FLYERS CREEK WIND FARM

REVIEW OF REPORT No 41.4963.R1A:ZSC – 15th December 2011

Review of The Acoustic Group Pty Ltd "Peer Review of Acoustic Assessment Report for Flyers Creek Wind Farm" No 41.4963.R1A:ZSC report dated 15th December 2011.

**March 2012
S3870C1**

**Loc 12 Background Noise at Receiver vs Wind Speed at Windfarm
78.6m AGL Total Regression**

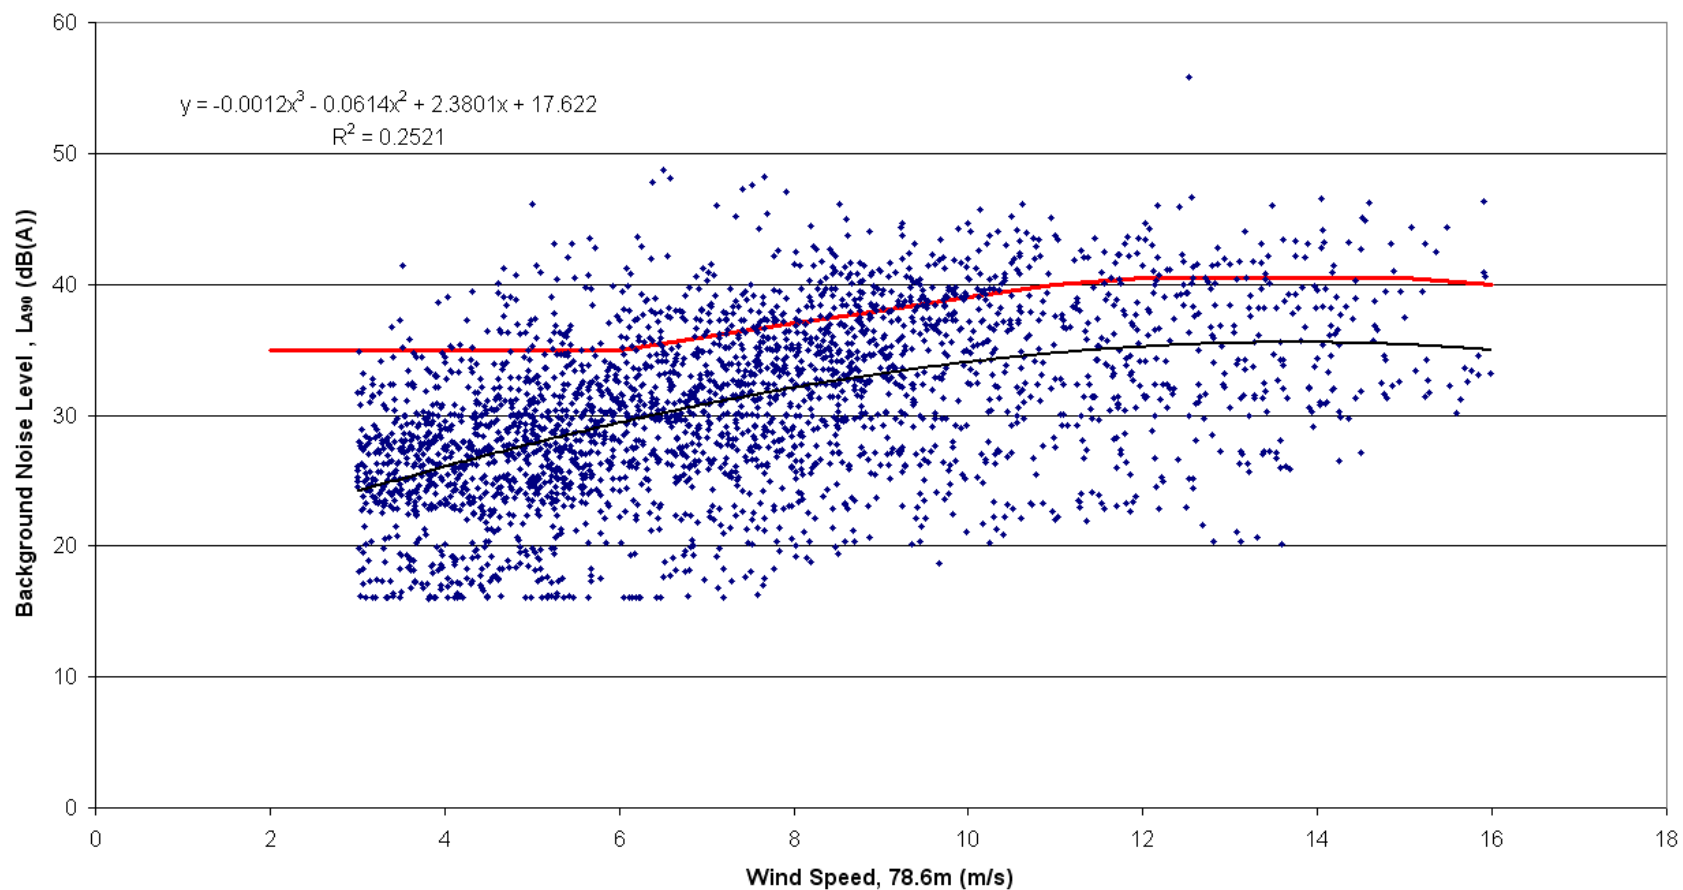
The Acoustics Group report indicates that the noise logger at location 12 was relocated from a position approximately 165m from the dwelling to a position approximately 34m from the dwelling.

In general terms, a remote location can provide representative background noise levels at a dwelling, provided the trees and structures in the vicinity replicate those adjacent the dwelling. It is possible that the background noise levels will be lower at a remote location away from trees or structures, which might result in the establishment of more stringent criteria. Notwithstanding, we understand that ViPAC did not utilise any noise logger data from the remote (165m) location in their report.

Recommendation: Based on no data being utilised from the 'remote' logger location, no further action is required.

Loc 78 Background Noise at Receiver vs Wind Speed at Windfarm
78.6m AGL Total Regression

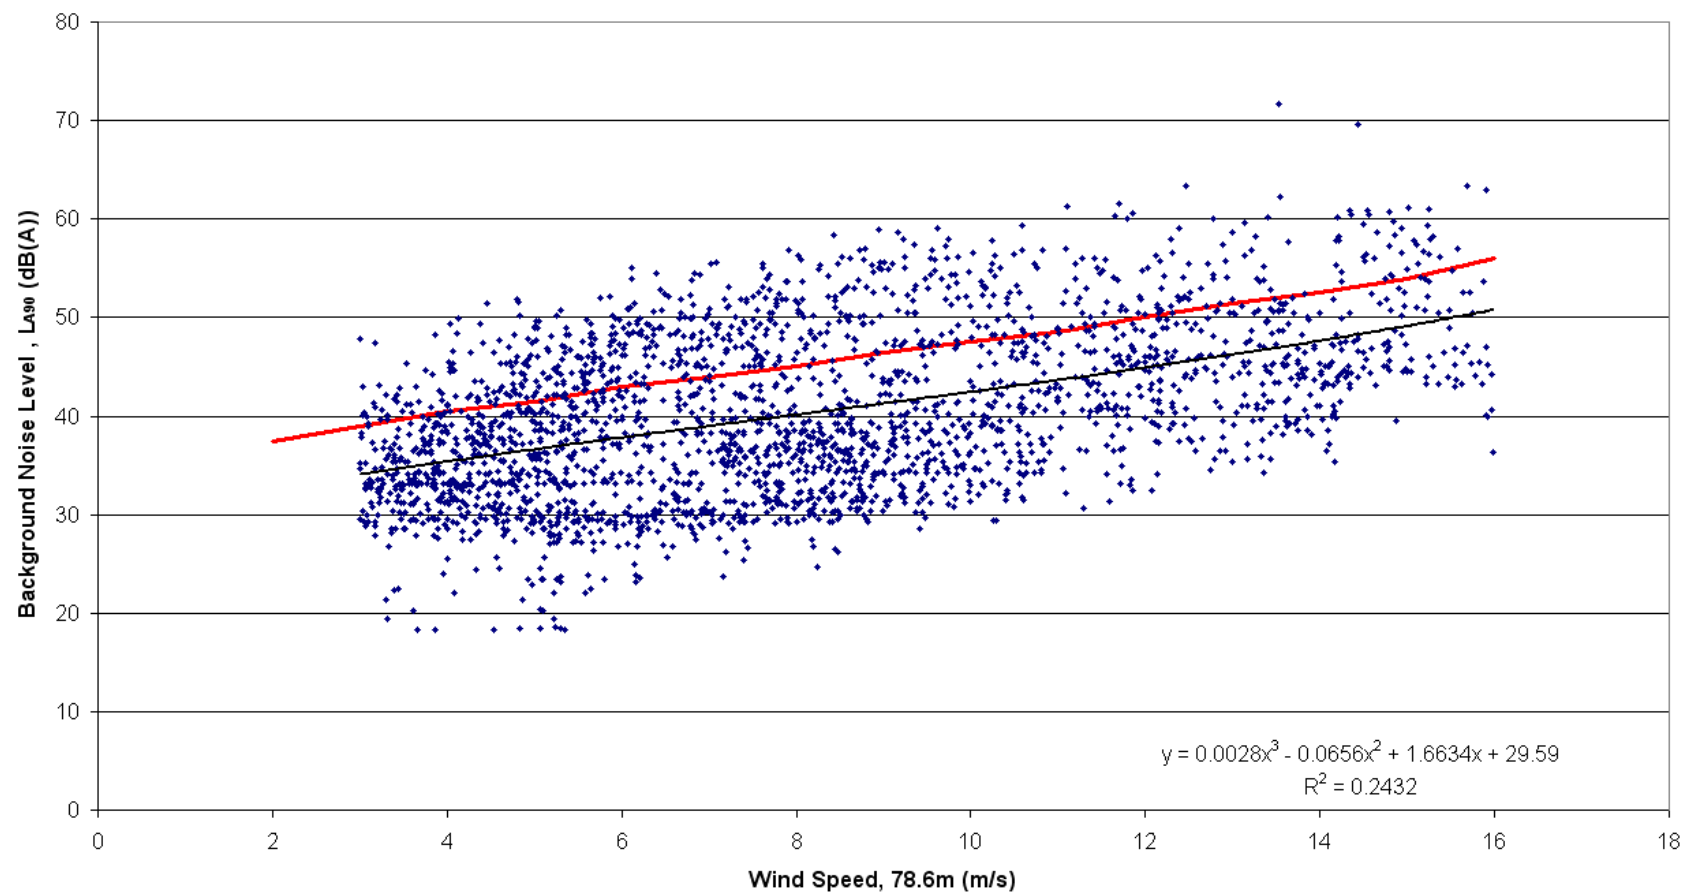
The Acoustics Group report notes that sound level meters used for the background noise monitoring at locations 78 and 89 appear to have a noise floor of greater than 20 dB(A).

The SA EPA Guidelines permit the use of Type 1 sound level meters and do not require a maximum noise floor level. ViPAC has stated that the background noise monitoring regime utilised Type 1 sound meters which typically have a noise floor of about 20 dB(A).

Recommendation: Re-analyse the data at locations 78 and 89 to remove the potential adverse impact of any noise floor. Alternatively, conduct a monitoring regime at these locations using noise level meters with low noise floors to collect the minimum 2000 valid data points required by the SA Guidelines.
